Please ask for: Ms Iqraa Malik
Email: iqraa.malik@terraquest.co.uk
Telephone: 01212341390
Our Ref: AW/158/20/HH
Your Ref:
Date: 10th July 2020

Application for Planning Permission for Works or Extension to a Dwelling

Development: Modular ramp to front door
Location: 7 Marlborough Court Aldwick PO21 5QH

7 Marlborough Court

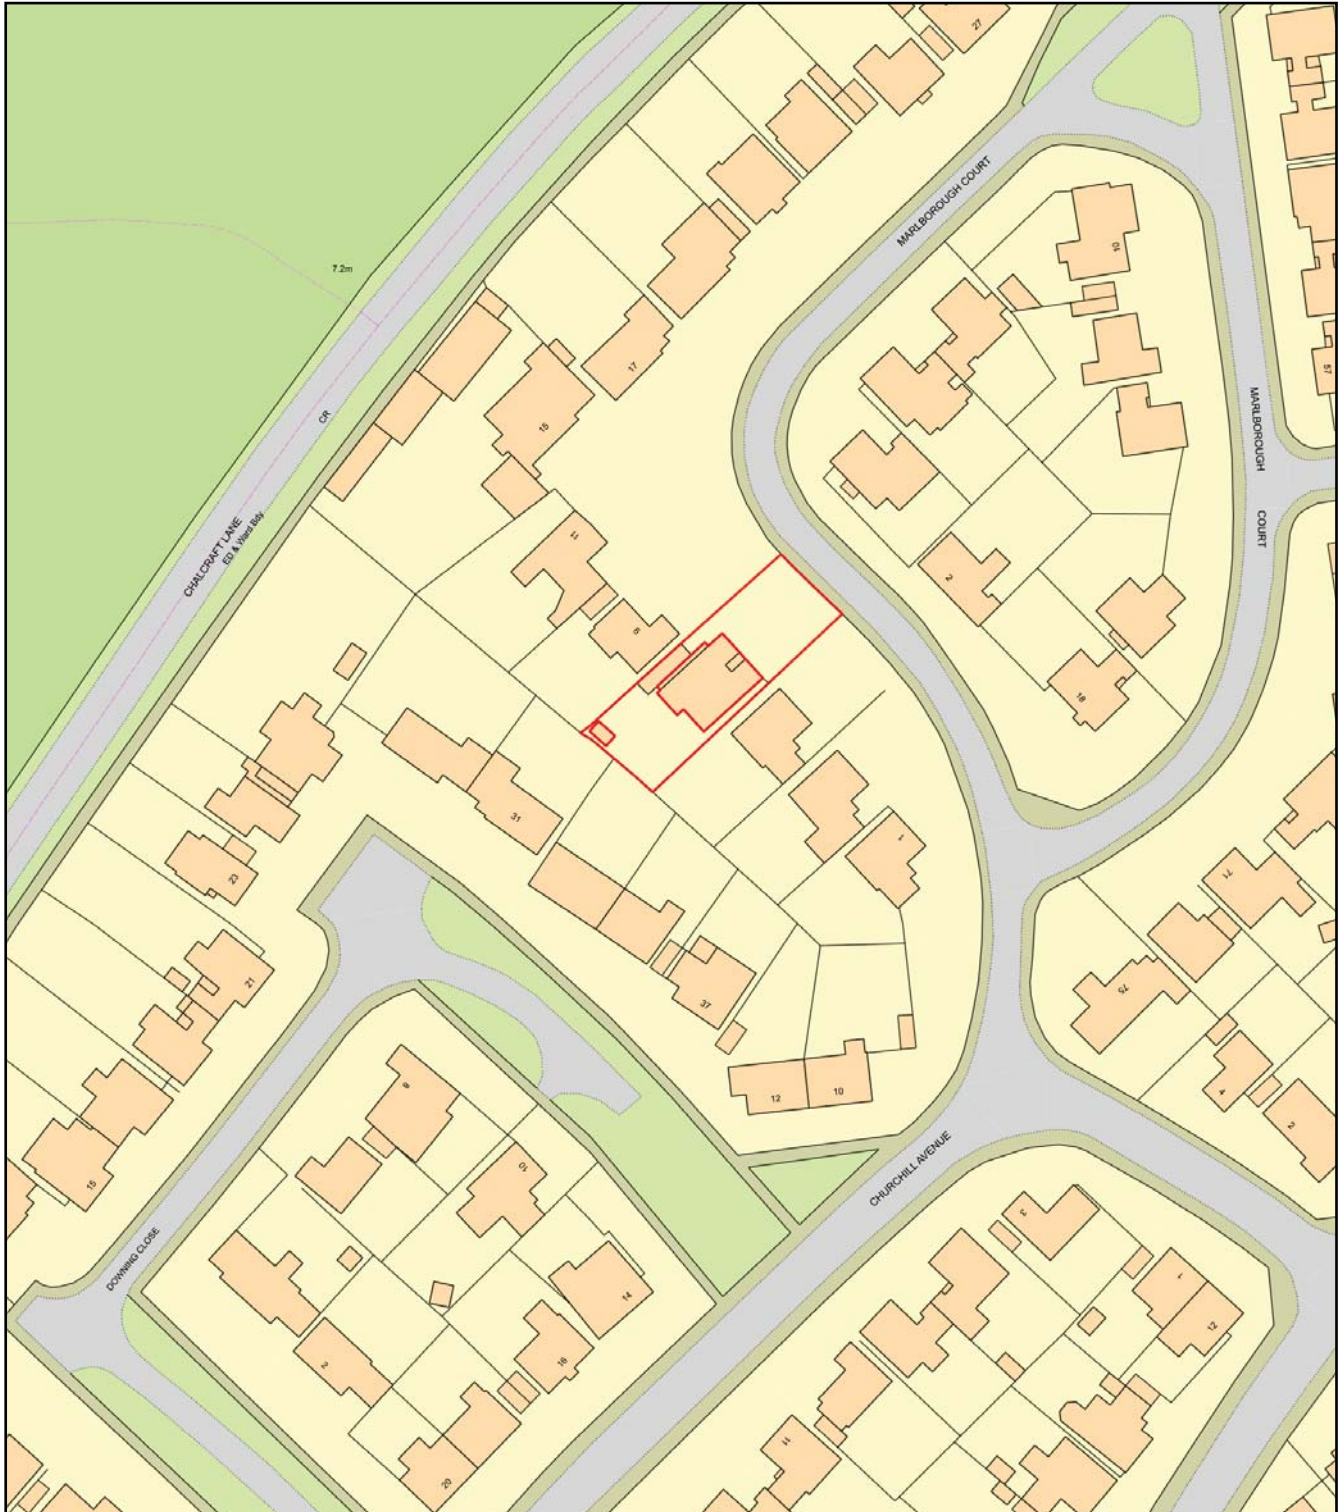
Block Plan

You are required to have clear dimensions from the proposed extension(s) to all site boundaries. The dimensions you have provided are unclear. Please amend.
